EP-21-0051_3 Waterbury PUD Preliminary Plan

Colorado Geological Survey has reviewed the Waterbury PUD preliminary plan resubmittal. The applicant proposes 198 single-family residential homes on approximately 62 acres located southeast of Highway 24 and Stapleton Road in Falcon. The available referral documents include a Letter of Intent (William Guman & Associates, Ltd. (Guman), March 10, 2022), Grading and Erosion Control plans (Terra Nova Engineering, Inc., March 3, 2022), PUD Development Plan and Preliminary Plan (Guman, January 27, 2022), Soil, Geology, and Geologic Hazard Addendum and Report (Entech Engineering, Inc., February 2, 2022 and October 18, 2021), and Master Development Drainage Plan (Terra Nova Engineering, Inc., March 2022).

Submitted 4/7/2022 by Amy Crandall, Engineering Geologist, Colorado Geological Survey

CONSTRUCTION SET
COVER SHEET

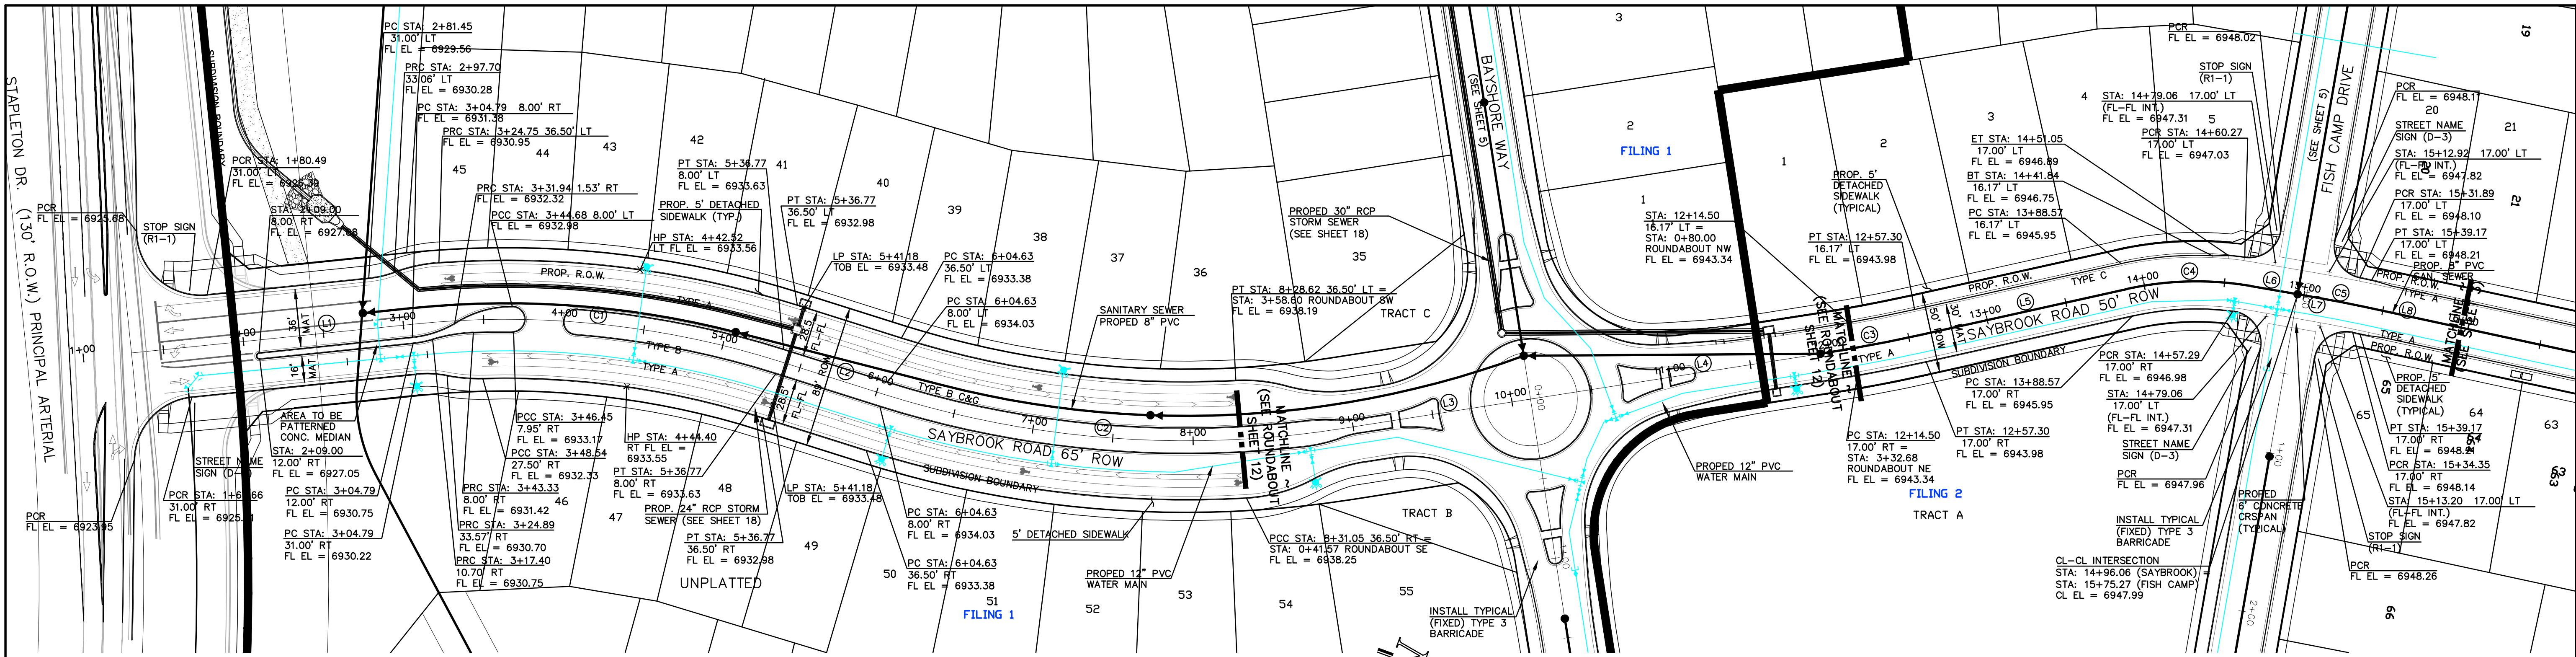
Note 28 of the Grading, Erosion, and Sediment Control should include Entech's February 2, 2022 addendum and October 18, 2021 report, or the most recent revisions.
